**Re: SSD 8894 Tower B (Detailed Design and Construction) at 12 Frederick Street,
St Leonards**

**SUBMISSION TO SSD 17 8894 APPLICATION NORTH SHORE PRIVATE HOSPITAL (TOWER B) STAGE 2
DESIGN AND CONSTRUCT, 12 FREDERICK STREET ST LEONARDS**

DESCRIPTION
TYPICAL FLOOR - 3 TO 8

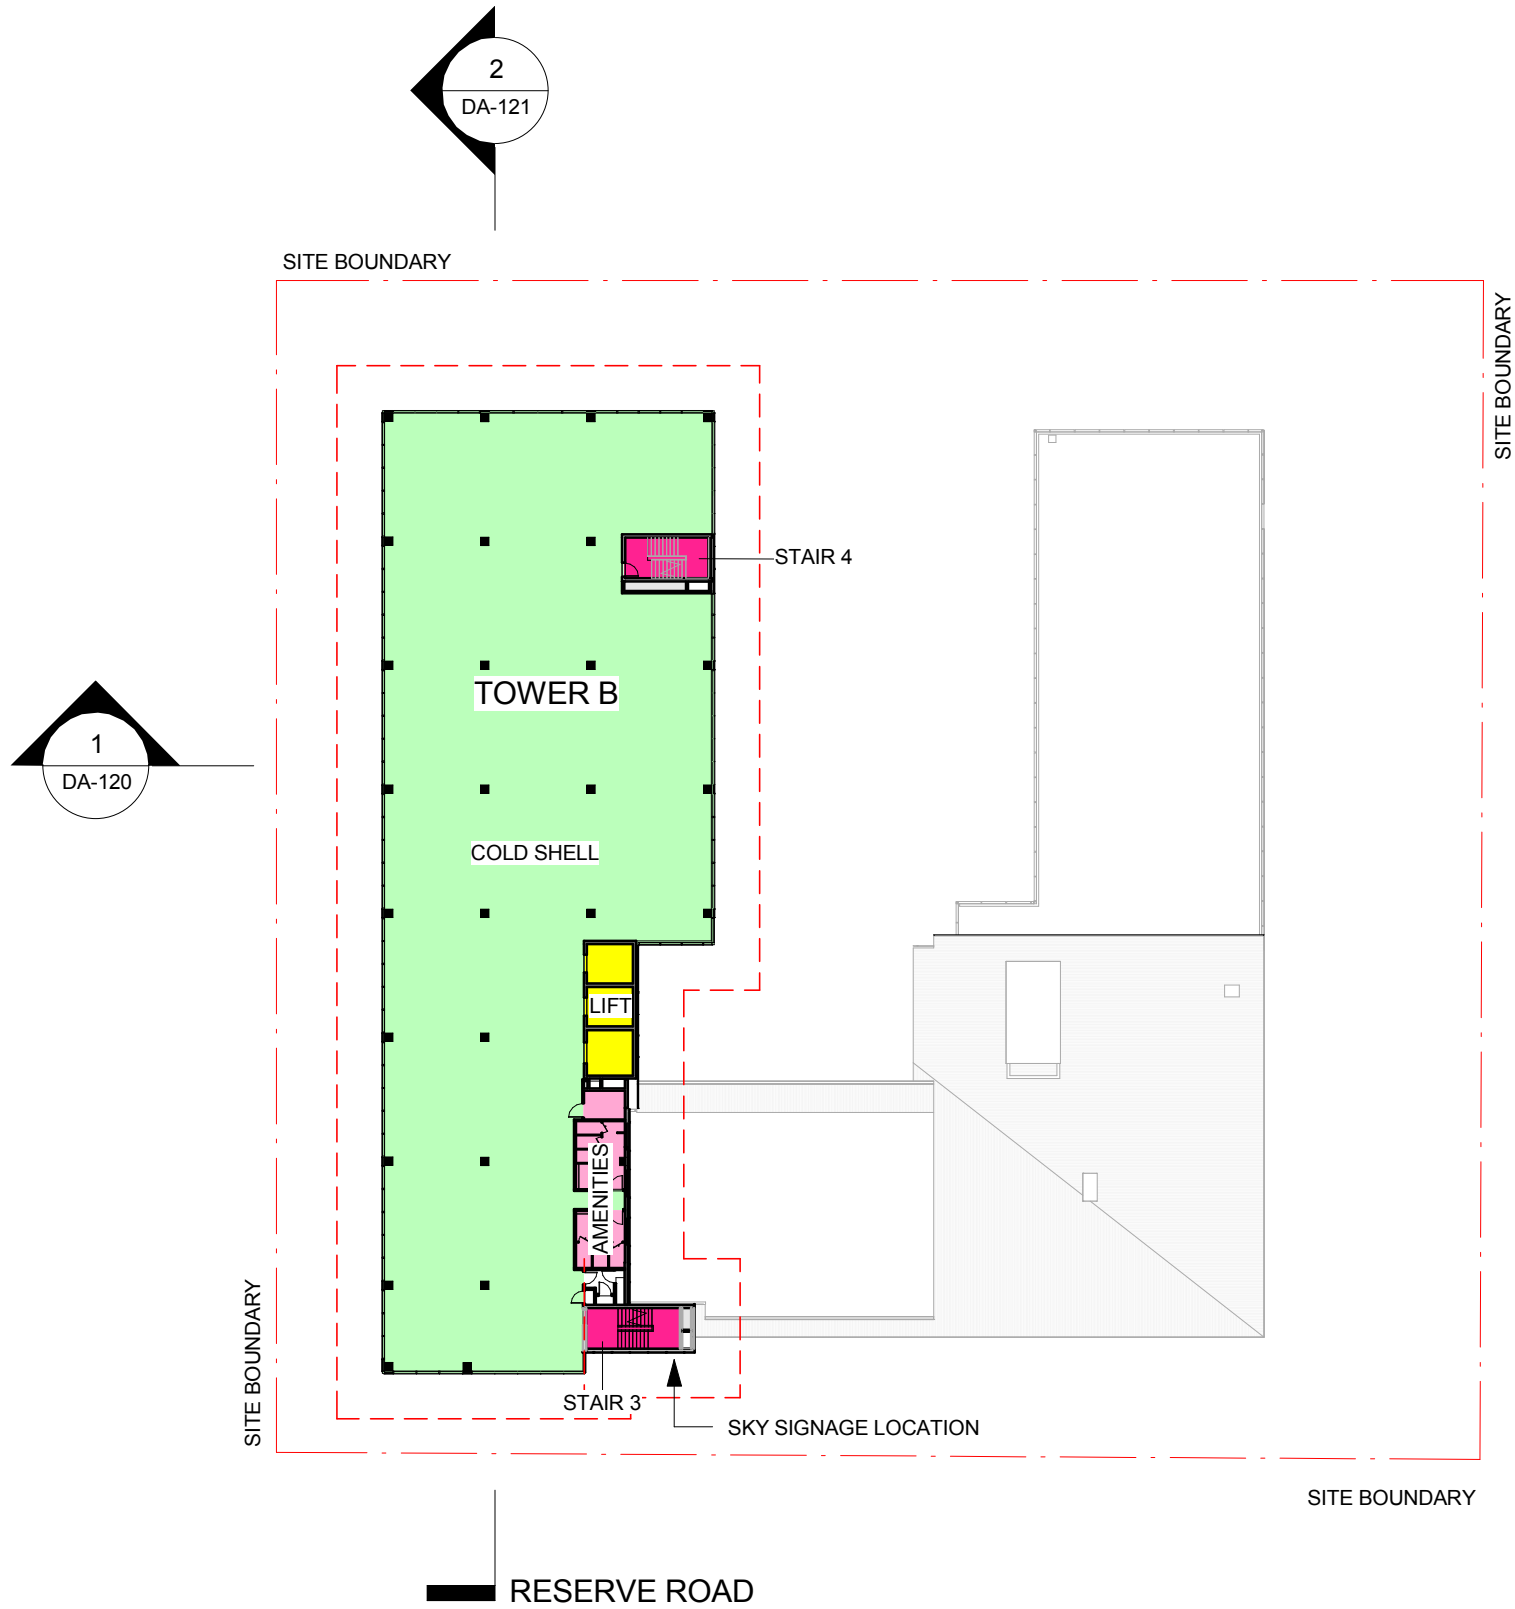
The Architectural Design Statement prepared by Billard Leece Partnership do not provide detailed DA level Architectural floor plans, which indicate information such as the location of the lift lobby, consulting room sizes and numbers, provision of waste storage rooms per floor etc. (Refer to extracts below, from page 13 and 16 of Report).

No detailed floor plans provided.

Insufficient documentation submitted to undertake assessment.

The Architectural Plans need to identify the location of the Fire Control Room in accordance with Clause E1.8 of the BCA and update plans in accordance with the requisite travel distances.

- > Detailed DA level Architectural Floor Plans and Landscape Plans are to be provided to enable accurate assessment of the proposed development. These plans are to include details of all room uses, windows, doors, access arrangements etc and details of any proposed landscape treatments.

That a full BCA report be provided to address the provision of the Fire Control Room and the requisite travel distances indicating consistency with relevant BCA standards.
